17th December 2019

**Application by Norfolk Boreas Limited for the Norfolk Boreas Offshore
Windfarm
Response to Deadline 3
Planning Inspectorate Ref: EN10087
Our Registration ID: 20022672**

We offer the following response to those questions directed at Archaeology and Cultural Heritage as set out within First Written Questions (dated 19th November 2019) and addressed by the Applicant.

Figure 8c

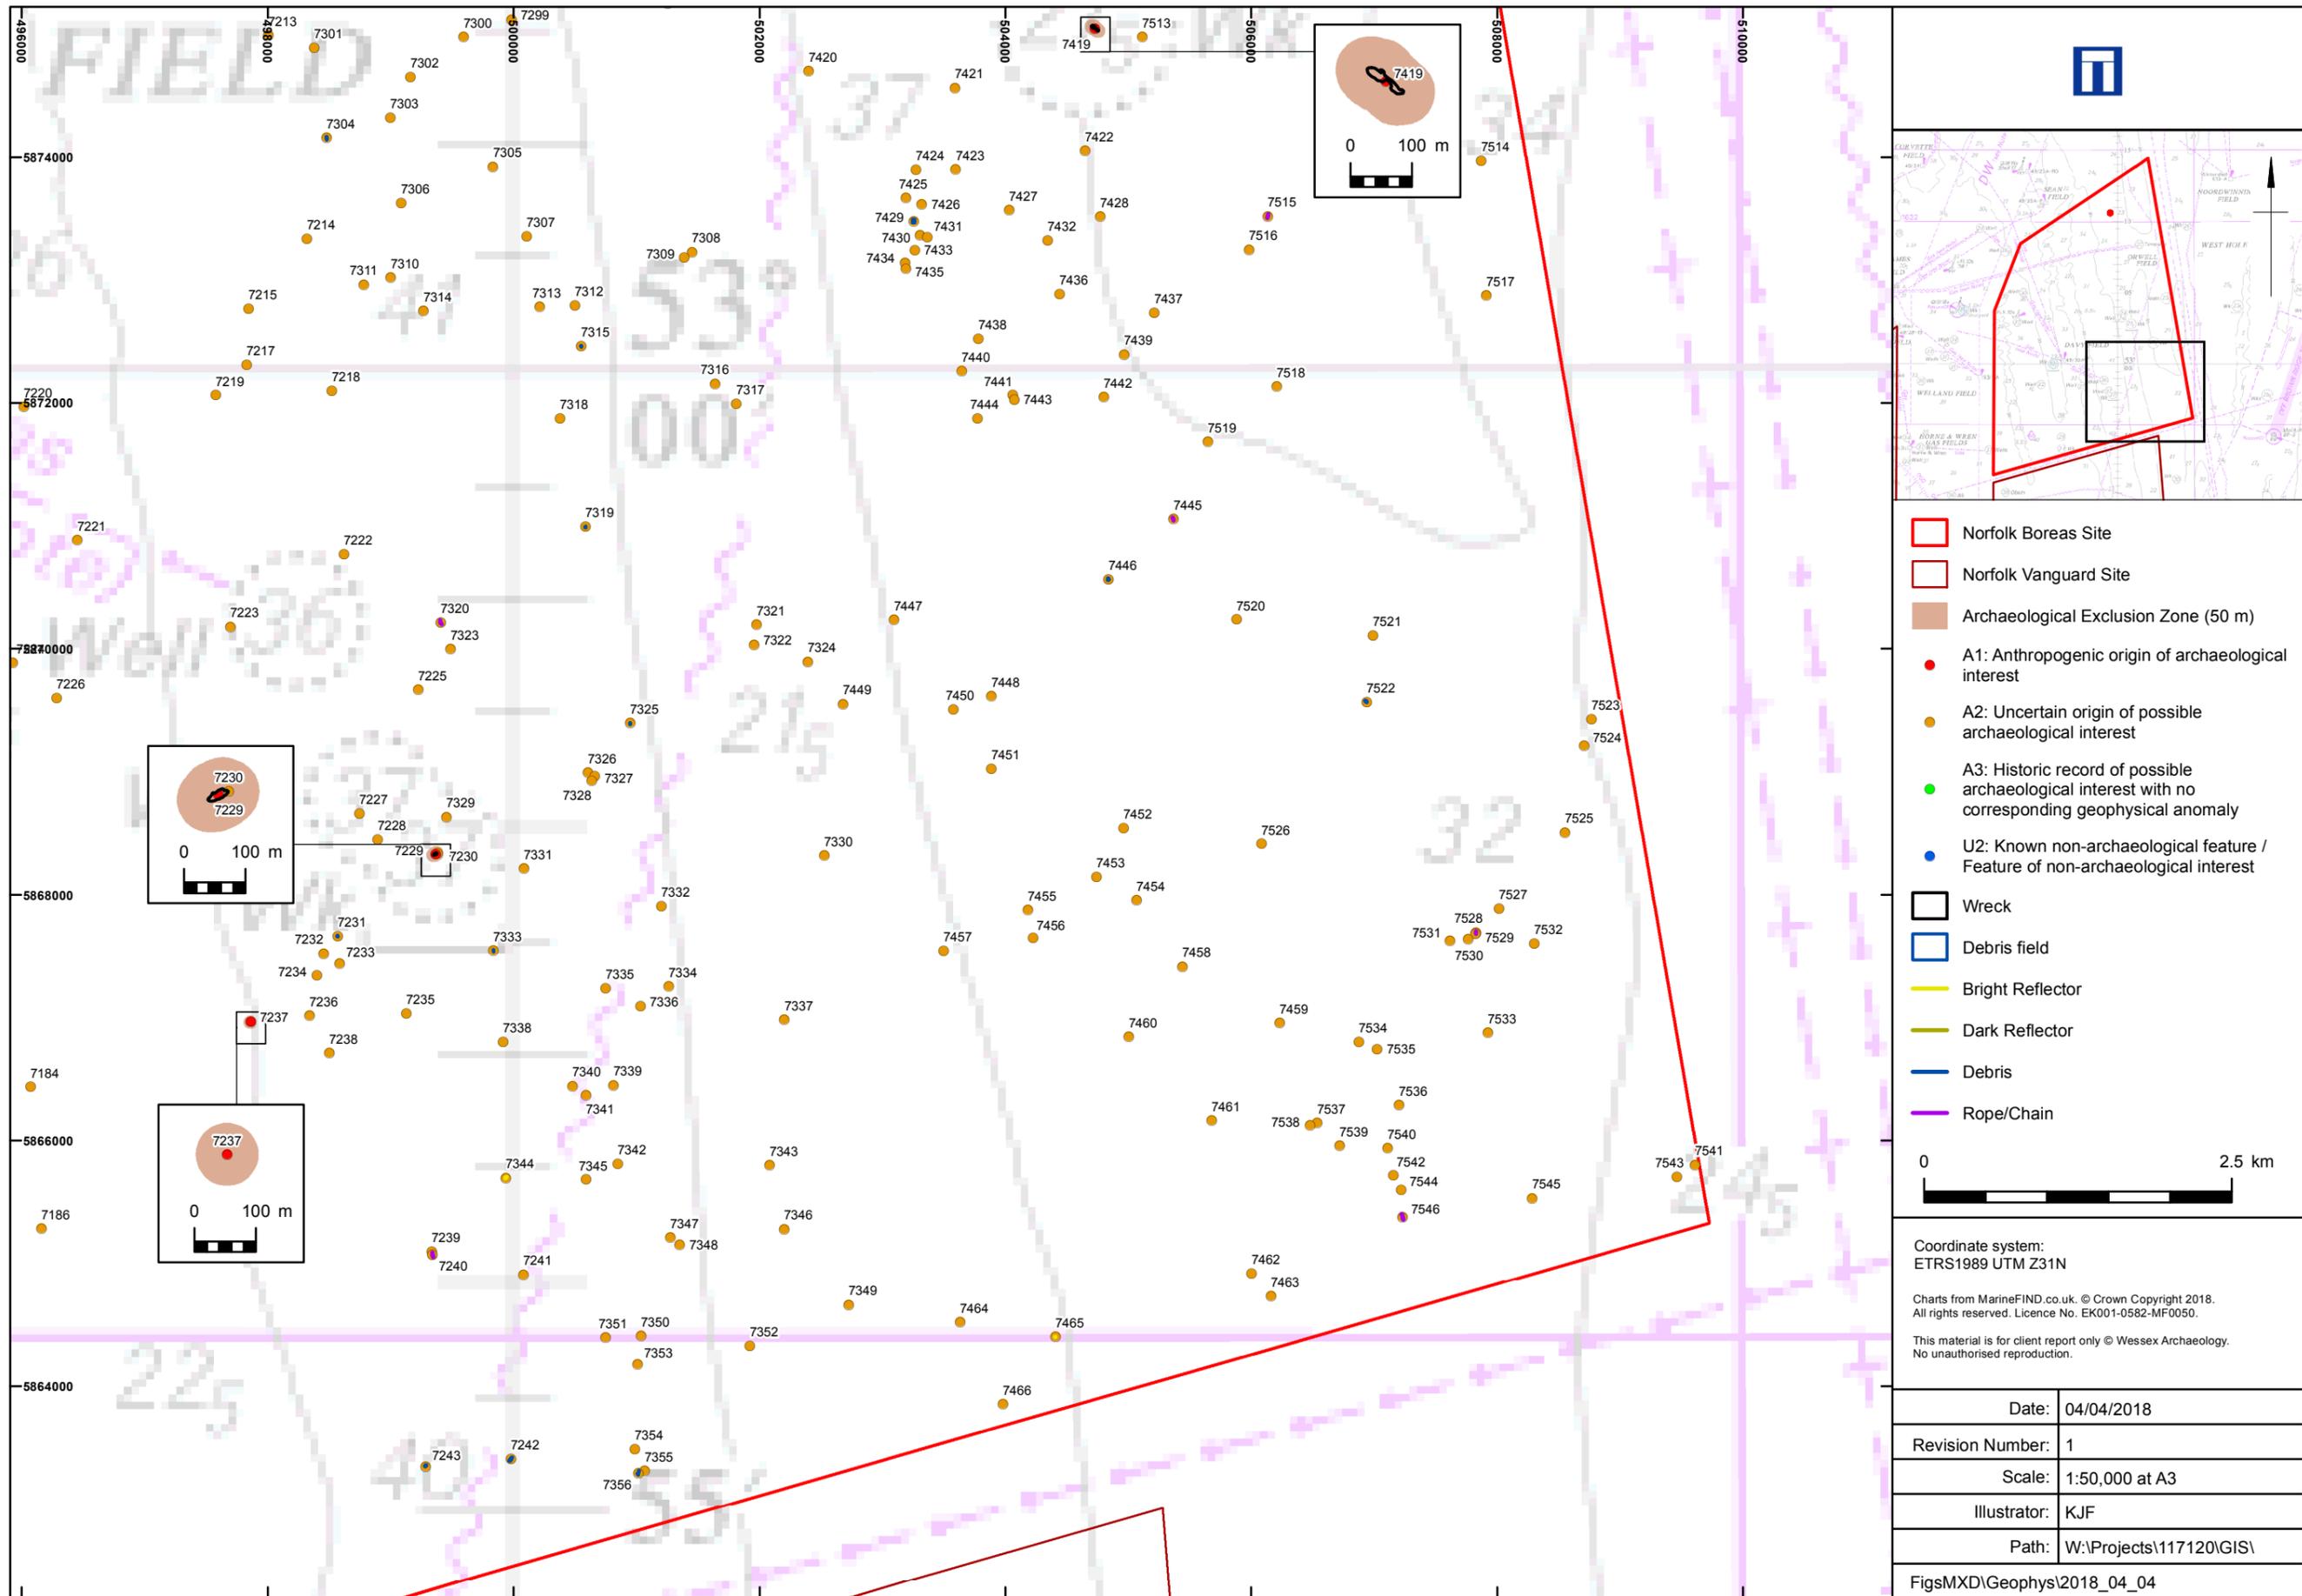
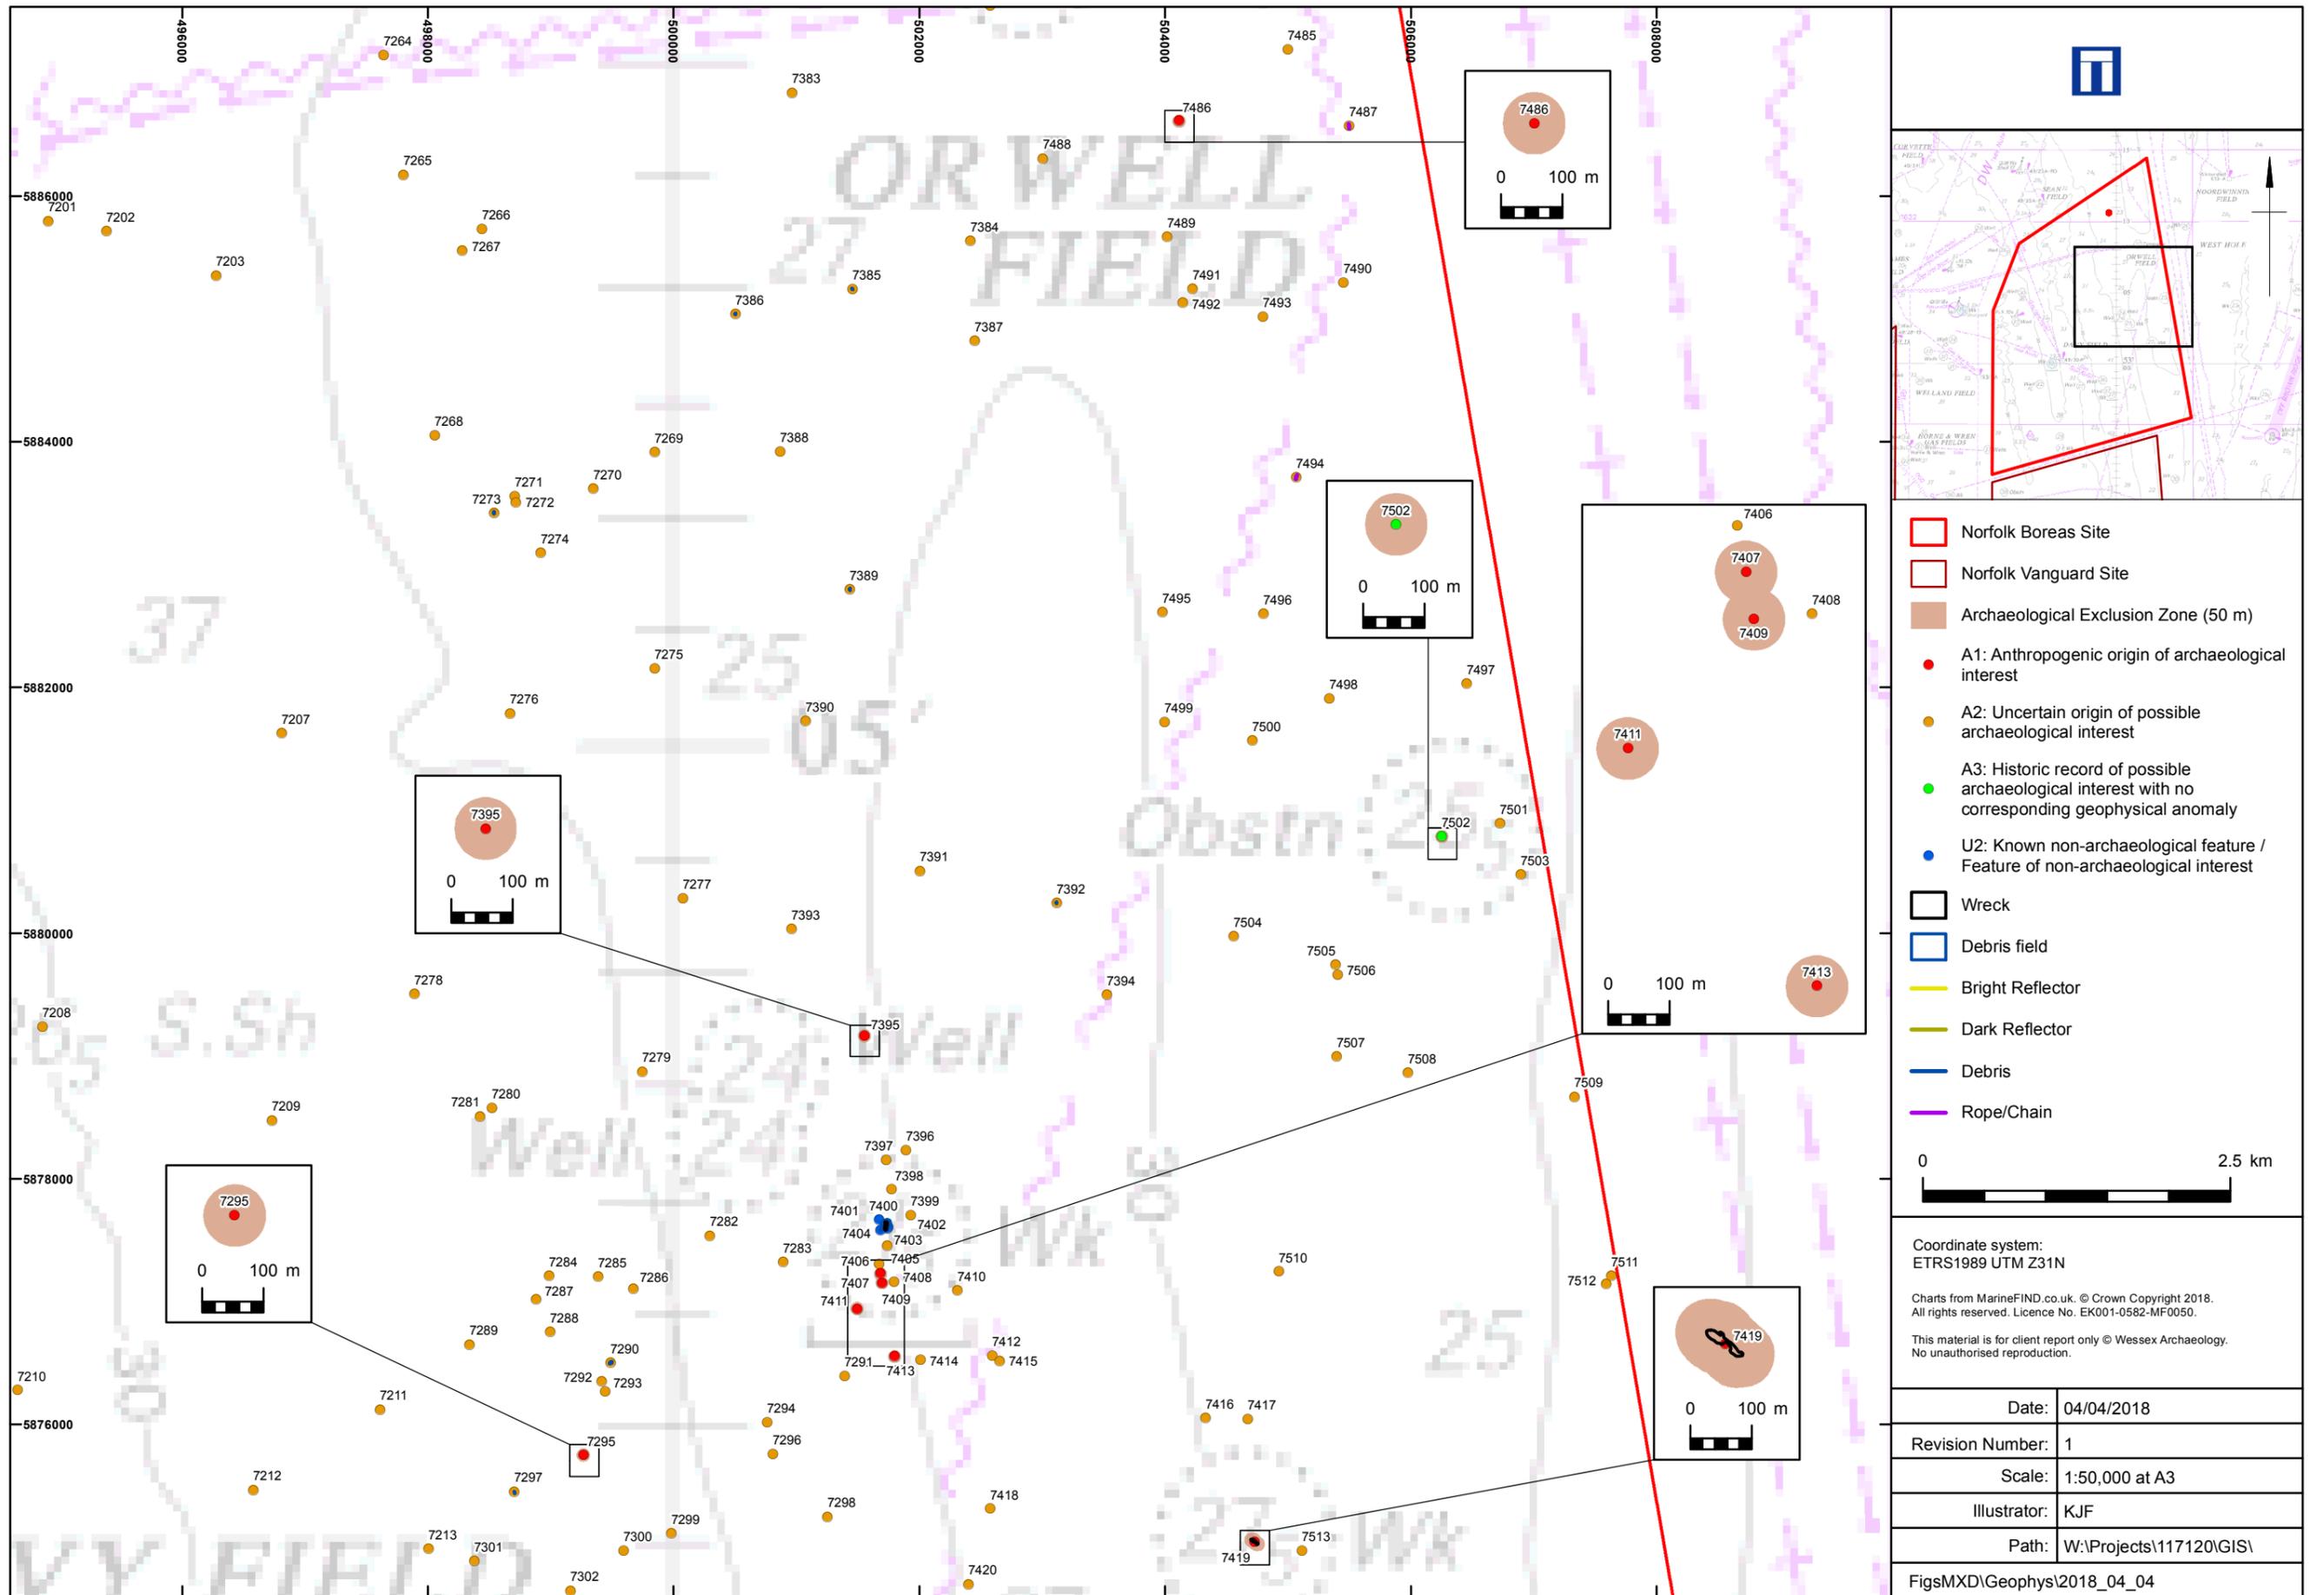
Response: The use of Archaeological Exclusion Zones (AEZs) is in recognition of different seabed development activities and their associated risk to either known or unknown elements of the historic environment as might be present. The primary function in the use of AEZs is as a mitigation measure to provide in-situ protection and therefore the spatial scale of an AEZ will vary on a case-by-case basis. It is therefore important that the archaeological Written Scheme of Investigation (WSI) produced from the outline WSI included within the DCO application explains how AEZs are identified, mapped, monitored and included within other relevant project delivery documentation used by the Consent Holder, contractors and sub-contractors (e.g. *Offshore In Principle Monitoring Plan*, DCO Document: 8.12, version 1, dated June 2019). In reference to the two designated historic shipwreck sites that exist within the proposed development Order Limits:

- The *Seagull* (Feature ID: 70809¹); and
- *Xanthe* (Feature ID: 70834)

It is important to offer the correction to the Applicant's response that these are now scheduled monuments and afforded statutory protection through the provisions of the Ancient Monuments and Archaeological Areas Act 1979. We also confirm that the List Entry for these two designated sites is available, as per the web links provided in our letter, dated 10th December 2019 (response to First Written Questions) submitted for Deadline 2. The List Entry also spatially defines the scheduled area, for both these designated heritage assets, as 100m in radius and therefore the minimum spatial extent of any AEZ must be amended to accordingly within any offshore archaeological WSI produced post-consent, should permission be obtained.
